City of Albuquerque Stormwater Construction Site Inspection Report

ESC File No.	D17E095A	Project Name:	Guthrie's Garage		
NPDES Id. No.	NMR1005KO	Location:	3831 Masthead Street		
10/23/2023	Owner	Contractor NMR1005M8			
Operator	Headstart Enterprises LP		Wilger Enterprises		
Contact name & title	Jim Guthrie		John Wilger & DA Gilbert Ramirez		
e-mail	jim@carcrafters.com		jwilger@wilger.com		
Contact Phone #	881-8889		505-345-2854		
COA Inspector	Doug Hughes		Start/End Time:	3:15PM	
Construction Phase:	Building block walls				
Type of Inspection:	<input type="checkbox"/> Regular	<input type="checkbox"/> Storm Event	<input type="checkbox"/> Post Storm Event >0.25"	<input type="checkbox"/> 311/Complaint <input checked="" type="checkbox"/> Follow Up	
Weather at time of inspection?	Clear		Temperature: ~	65	
Estimated date of last storm 0.25" or greater	10/16/2023

ENGINEER'S SEAL RONALD R. BOHANNAN NEW MEXICO PROFESSIONAL ENGINEER 7868 4-17-23 RONALD R. BOHANNAN P.E. #7868	3831 MASTHEAD ST ALBUQUERQUE, NM	DRAWN BY pm
EROSION CONTROL PLAN		DATE 4-17-23
		DRAWING
		SHEET # SW-1
		JOB # 2022002

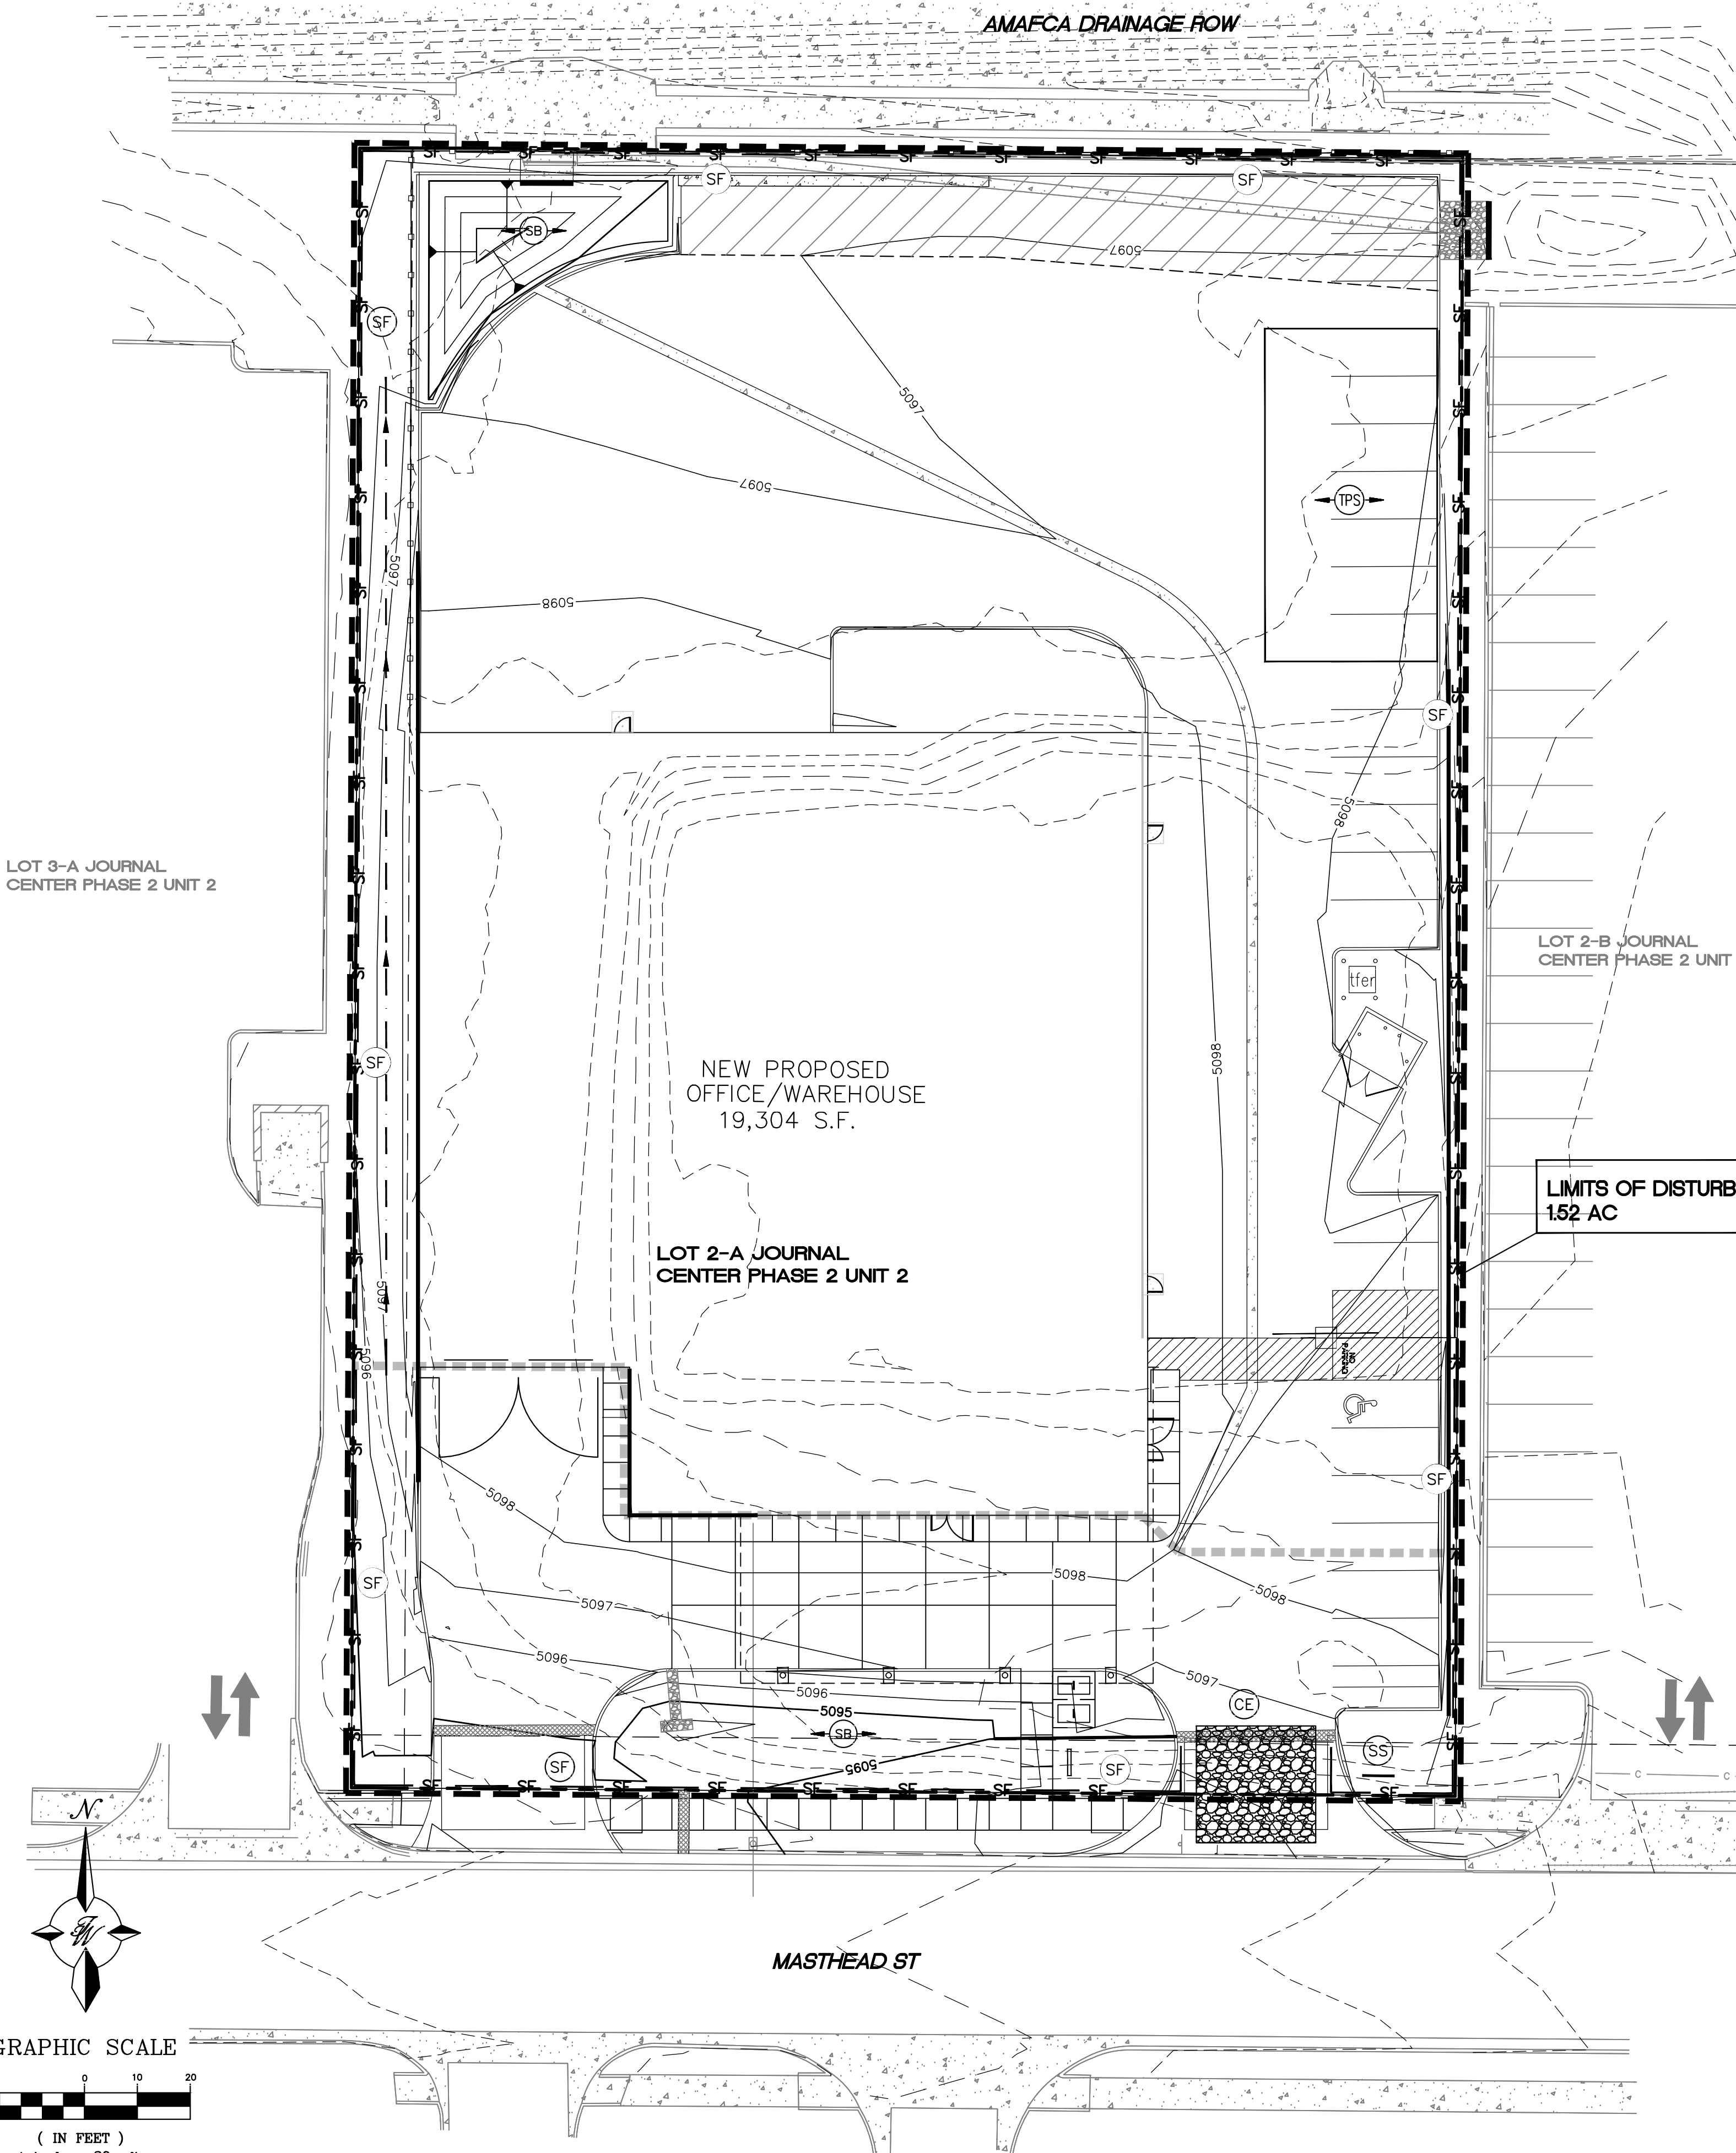
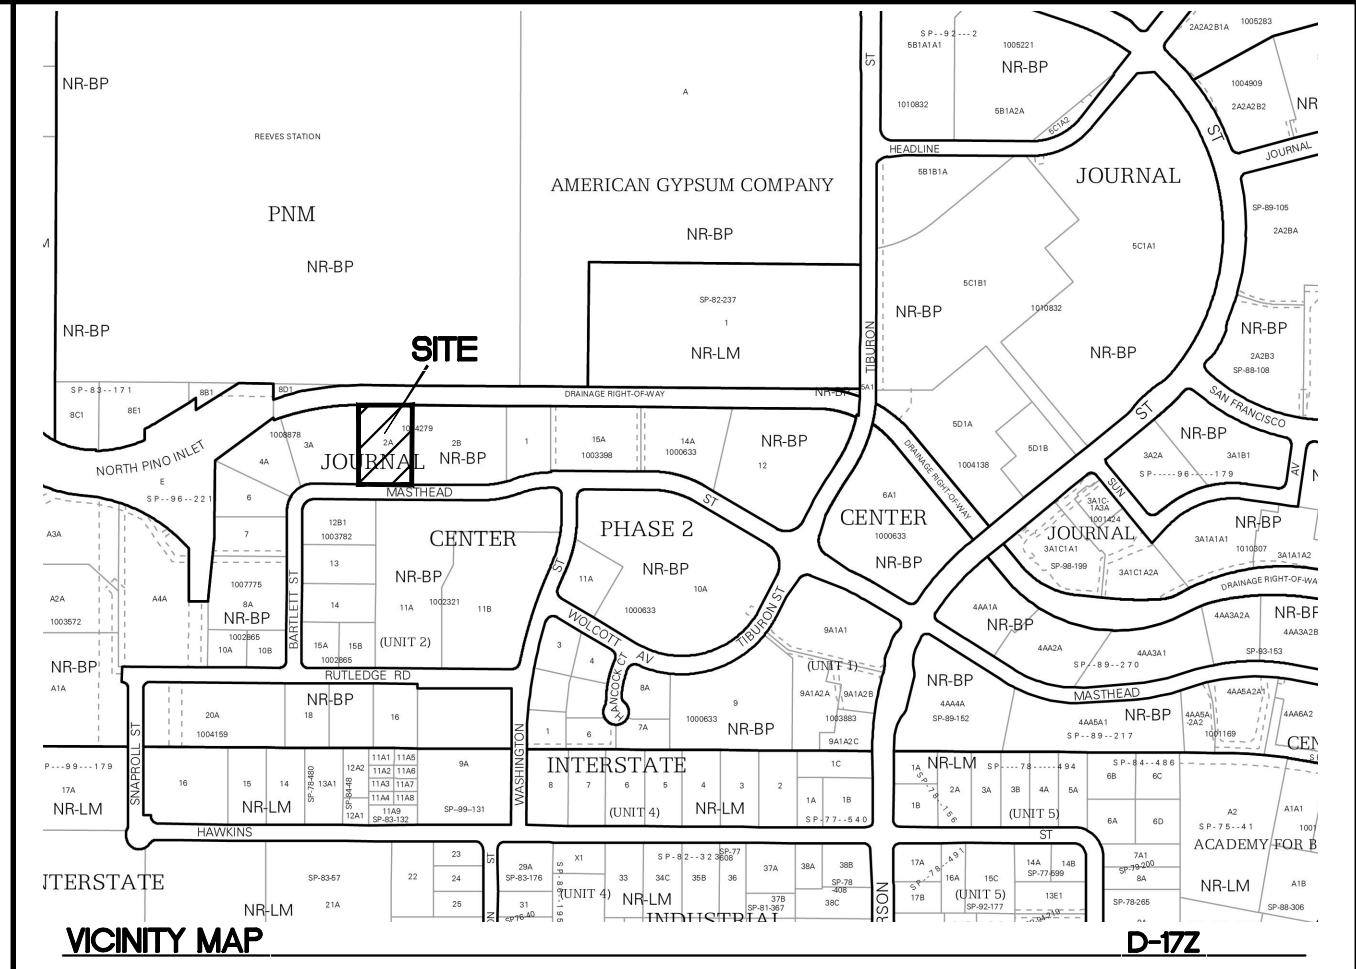
Item Number	Deficiency/ Corrective Action				
1	None				
2					
	Discharge off site? (Y/N)	no			
4	Self Inspection Reports	requested	Latest report Date:	8/9/2023	
	The SWPPP certification statements were signed by both operators and they both Delegated Authority (DA) to Gilbert Ramirez, superintendent. SWPPP is in the Conex.				
Required mitigation for Sign and email reports - Washout!
